From: caroline Champion [REDACTED]
Sent: 26 June 2021 22:18
To: Nicola Spencer
Subject: Re: Outstanding items for FP/107/21/HH

GROUND FLOOR PLAN
OF EXISTING PROPERTY
Nº 4 DERWENT GROVE
P022 8NE

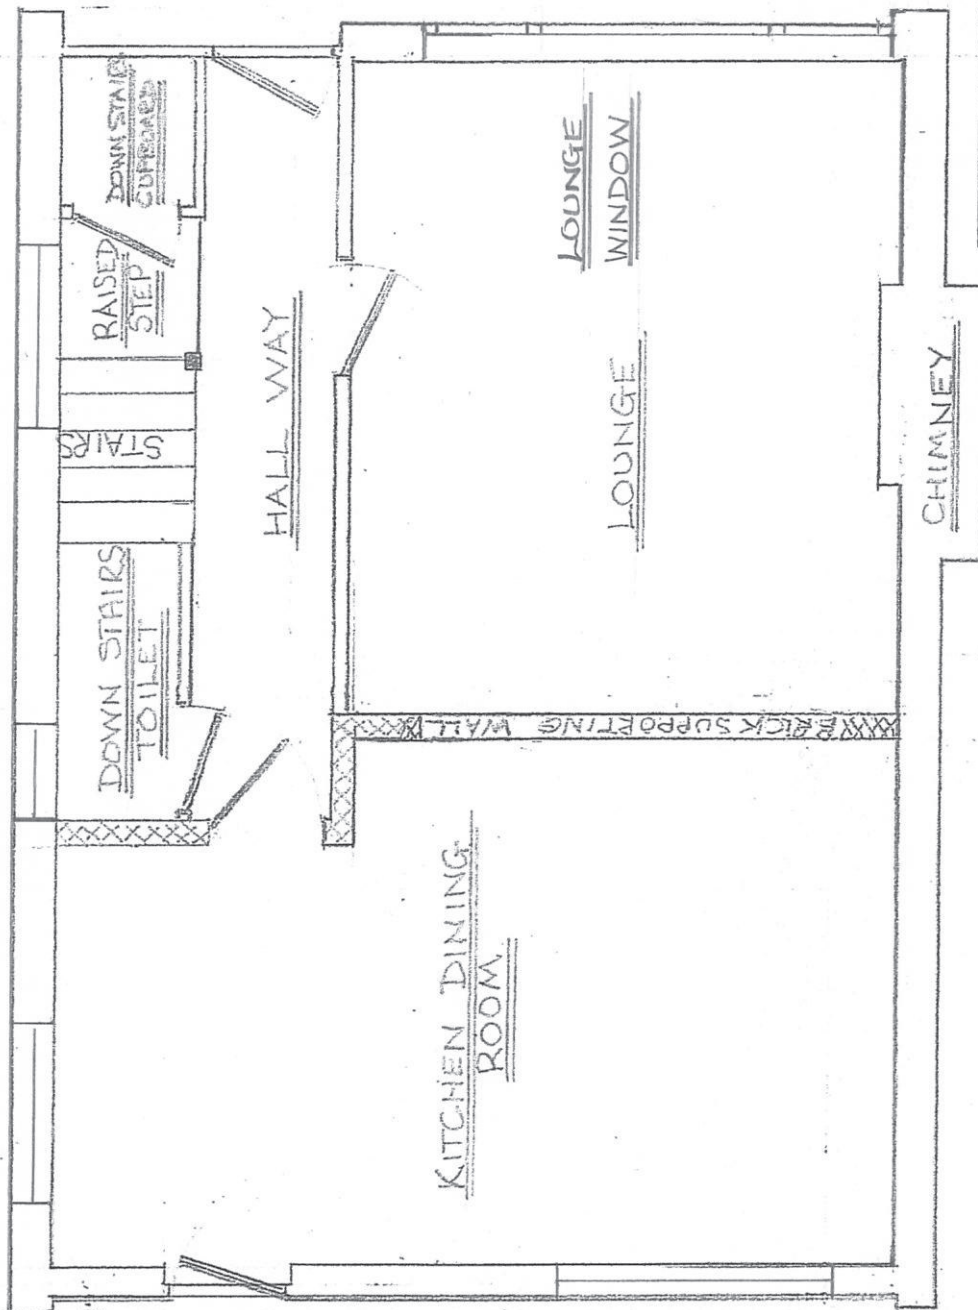
We need the equivalent of the proposed front elevation you have provided showing the existing front elevation and the existing floor plan (ie both without the porch and both drawings labelled existing.)

DRAWING SHOWING THREE ELEVATIONS
OF PROPOSED PORCH
DEVELOPMENT

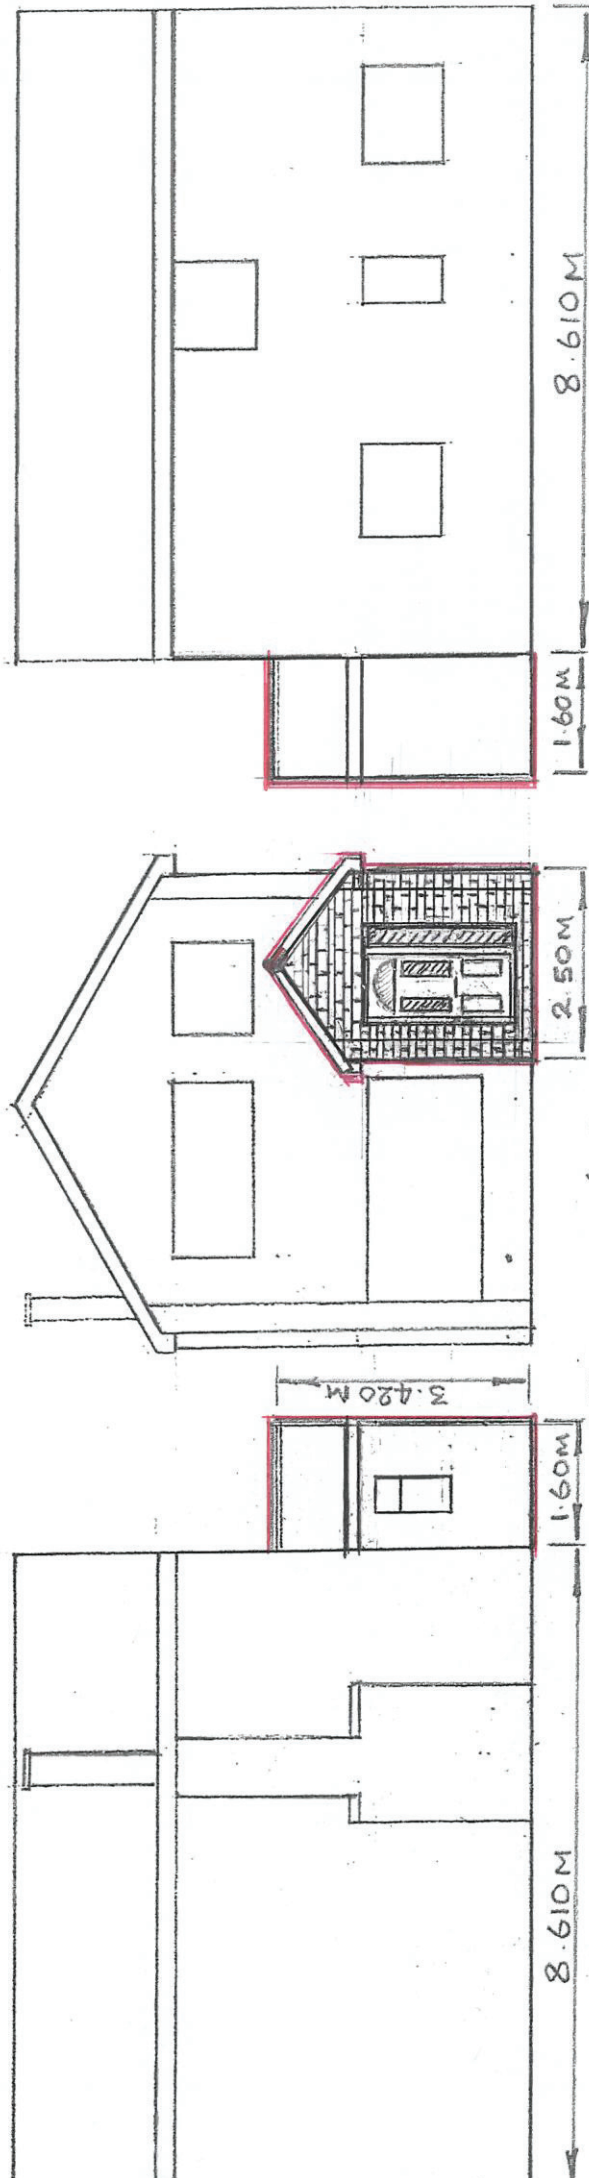
In addition we also require side elevations (From both sides of the property North West side and South East side) for existing (without the porch) and proposed (with the porch), in the same format as the plans you have submitted with the measurements clearly shown for the porch and clearly labelled existing and proposed.
